KITITAS COUNTY

TO: All Staff
FROM: Justin Turnbull, County Surveyor 
DATE: May 9, 2018
SUBJECT: County Survey Review of BLA BL-17-00006 (IOOF)

PART OF STATE ADDITION AND PART OF THE NORTHEAST QUARTER OF SECTION 36, TOWNSHIP 18 NORTH, RANGE 18 EAST, W.M.

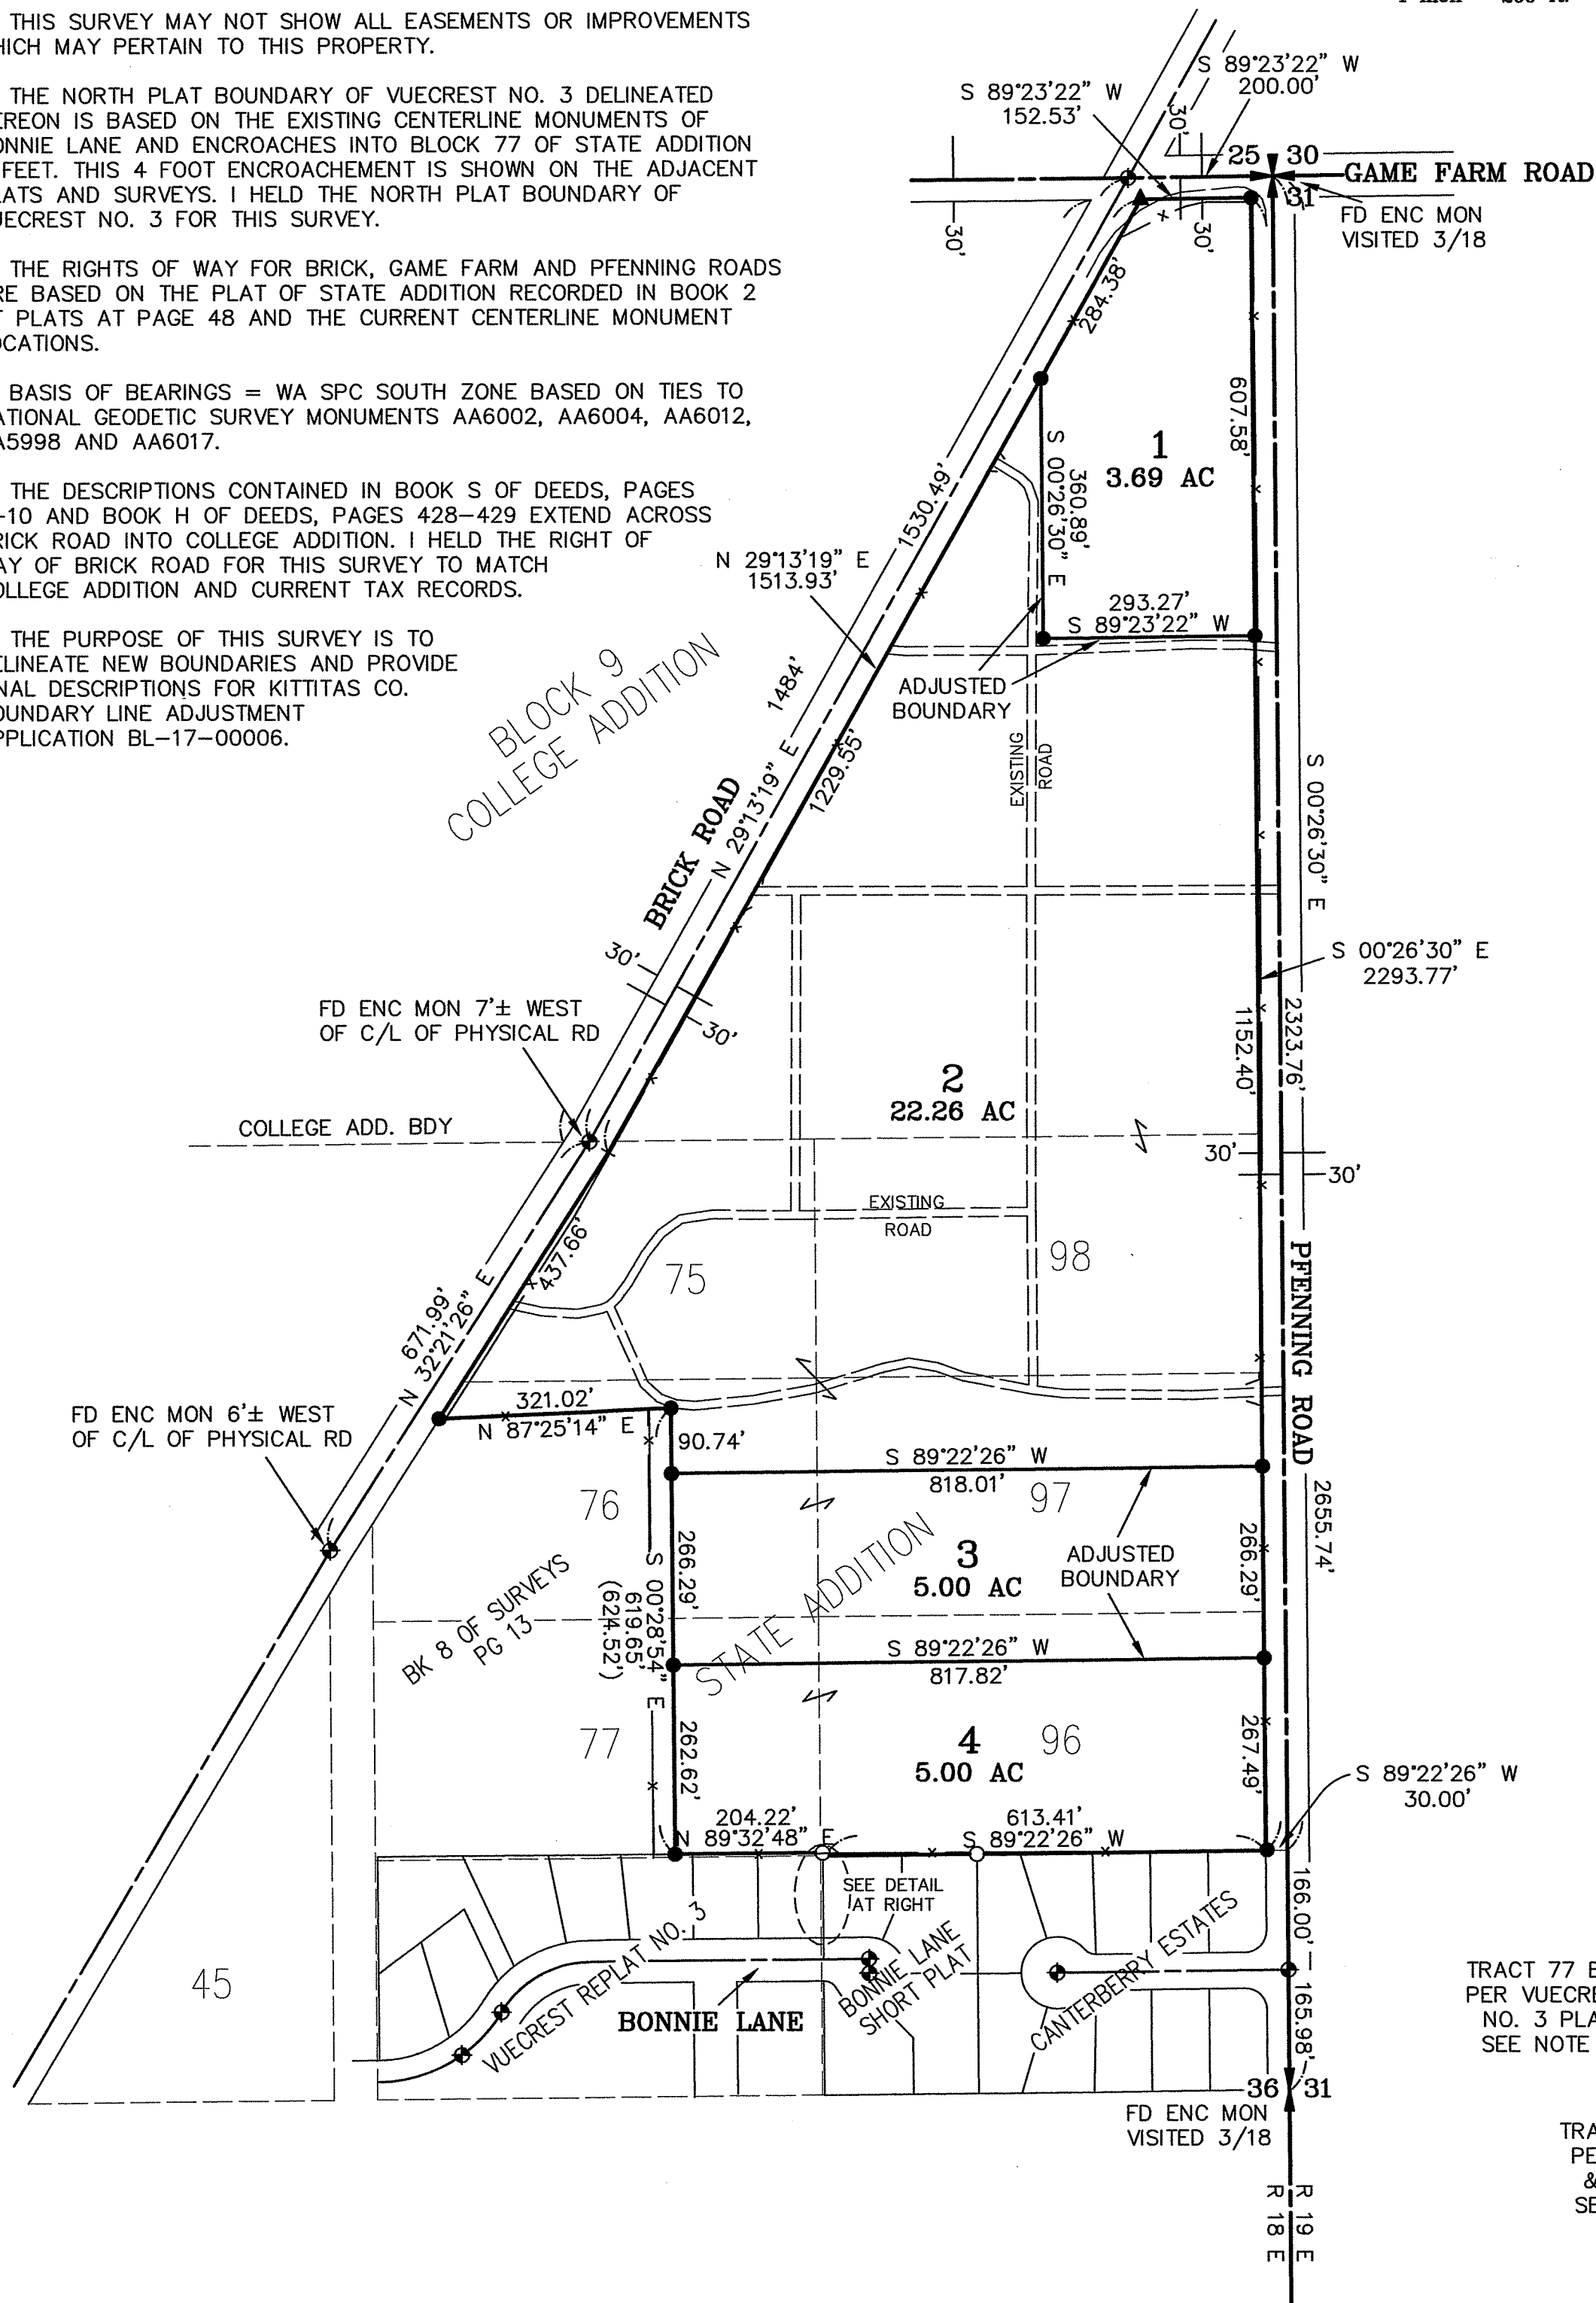
1. The existing legal descriptions shown are nonspecific in nature. Please correct.
2. Please note previous boundaries (or existing boundaries).
3. The dimensional tick (crowsfoot) for the section line are different sizes at each end.
